Proposed Development At 110 Harriet Street, Cathays, Cardiff, CF24 4BX.

Statutory Consultee Responses

From: Wellbeloved, Simon <[REDACTED]>
Sent: 21 December 2023 20:30
To: Clodagh Macken
Cc: Perry, Matthew
Subject: RE: PAC - 110 Harriet Street, Cathays

Figure 3 Extent of Parking Survey

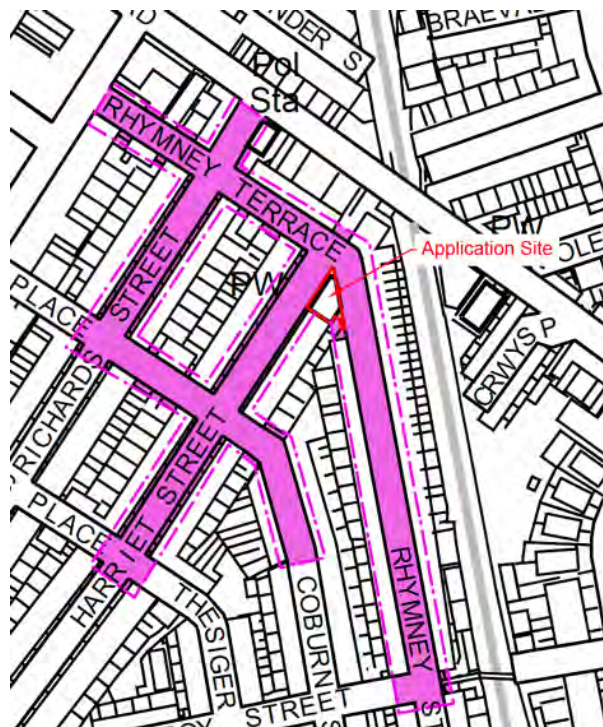
- a) There are inaccuracies in the DAS which I correct in my general comments below.
- b) Clarification on the guidance used for the Parking Beat Survey is required as my copy of the London Borough of Lambeth Parking Beat Survey seems to have a different extent of survey criteria from the extent of survey carried out to support this planning application.
- c) Only one early morning snapshot survey has been carried out in total. The guidance states a minimum of two snapshot surveys should be carried out.
- d) The snapshot survey was done outside University of Cardiff's academic year, and Cathays consisting of a large number of HMO's housing students, the parking survey

carried out is therefore not likely to be representative of parking stress on street inside University of Cardiff's academic year.

e) No surveys have been done during the day of on street car parking availability and turnover especially at the eight on street car parking spaces on Rhymney Street fronting the application site.

Figure 4 Proposed Development

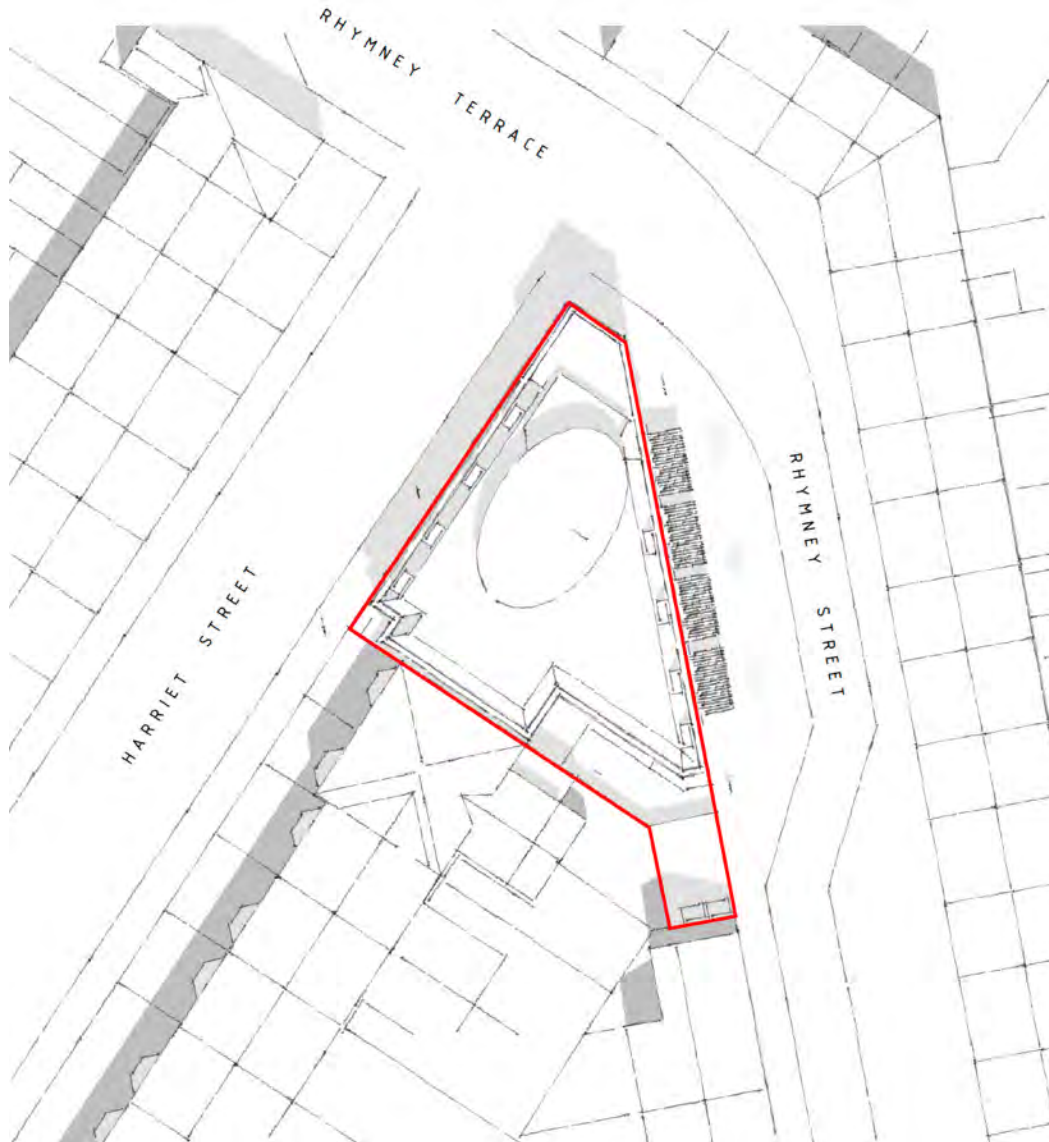
f) Servicing is proposed at the kerbside and given the narrowness of the carriageway of the streets in Harriett Street, Rhymney Terrace and Rhymney Street and all kerbside parking controlled by resident's parking bays, double yellow lines and the loss of short stay car parking, vehicles will double park whilst servicing the uses at the application site. This is not acceptable as access must be maintained at all times for vehicles.

g) It is understood that the place of worship closed some time ago, dwindling in congregation and was not used for other activities. I have concern due to the narrowness of carriageways and the parking restrictions admittedly during the day that cars will double park whilst they drop off or pick up young people attending community activities e.g. nursery groups, play groups, dance classes blocking access. Limitation on activities uses can be provided in the community space. This is another potential reason why it is not a good idea to remove on street short stay parking.

h) Due to the church probably being built before the rapid expansion of car ownership and use, there is no on-site car parking spaces. Whilst Cardiff SPG Managing Transportation Impacts (Incorporating Parking Standards) adopted in July 2018 (SPG) sets out the maximum number of car parking spaces that can be provided on site based on land use and strategic parking area (i.e. Central and Outer), the SPG sets out no minimum number of on-site vehicle parking spaces that must be provided. However, the Local Highway Authority must be satisfied that the proposed development would not cause parking stress within a specific distance of the site. It is observed that one of the ground floor rooms will be an accessible room, there is no guarantee that a disabled person with limited mobility would be able to park in immediate or close proximity to the building and will have to move their car prior to the start time of the CPZ operation. There will be no where for a taxi to pick up and drop off without double parking on street, if all kerb side spaces in the immediate and close proximity to the are fully occupied.

i) No covered cycle parking has been provided for staff and guests to this development, but six short stay uncovered cycle parking spaces are proposed on the widened footway. The latter will be subject to the Local Highway Authority excepting at eight on street vehicle parking spaces can be lost. A planning condition will be required restricting the permitted change of use of the apartment hotel to residential dwellings, if not, the Local Highway Authority will be expecting a minimum of one covered and secure on site cycle parking space per room, for the apartment hotel element of this development. Based on current development quantum seventeen covered on site cycle parking spaces in this development would be required.

k) If the Local Highway Authority were minded to allow the proposed footway widening, the applicant will be responsible for funding the Councils costs in regard to technical checking, any commuted sums payable to the Council and implementation of the highway works to the satisfaction of the Local Highway Authority. The highway works will likely be secured by a pre-commencement planning condition.
